From: Silvie Steiningerova
Sent: 20 August 2026 12:42
To: Planning.Responses
Subject: FW: 10 Downview Road, Felpham, Bognor Regis - FP/102/26/HH.
Attachments: Prop Elevations 2.pdf; Prop GF Plan 3.pdf

- Planning, FP/102/26/HH, Substitute Plans, Proposed elevations rev D- 04, Public
- Planning, FP/102/26/HH, Substitute Plans, Proposed ground floor plan rev C- 02, Public

From: Chris Moore [REDACTED]
Sent: 19 August 2026 11:36
To: Silvie Steiningerova <Silvie.Steiningerova@arun.gov.uk>
Cc: Planning <Planning@arun.gov.uk>
Subject: 10 Downview Road, Felpham, Bognor Regis - FP/102/26/HH.

PROPOSED ELEVATIONS

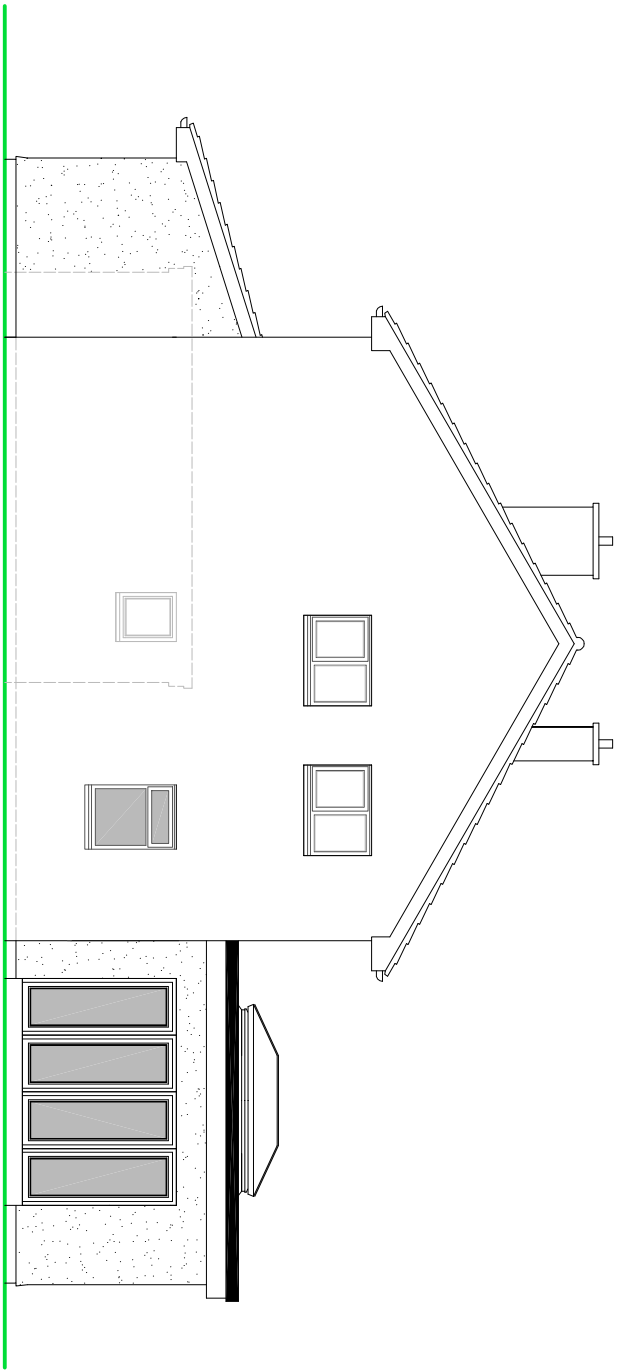
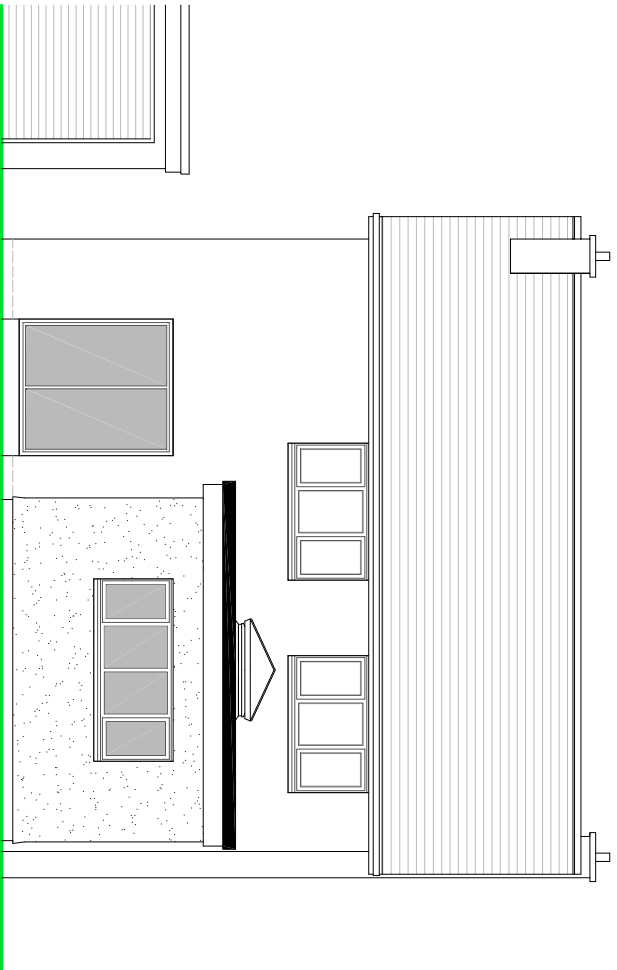
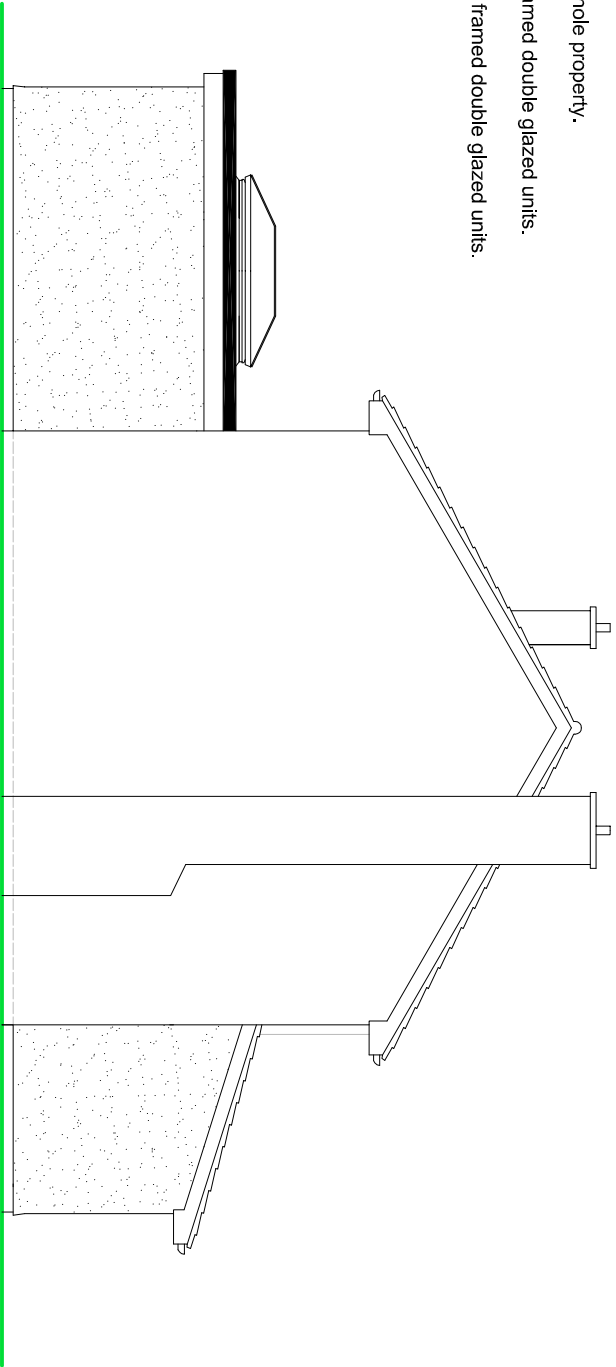
I refer to the above and the client has instructed me to amend the proposed wall finish to the rear extension to render – please find attached revised GF Plan and Elevations – please can these be considered instead?
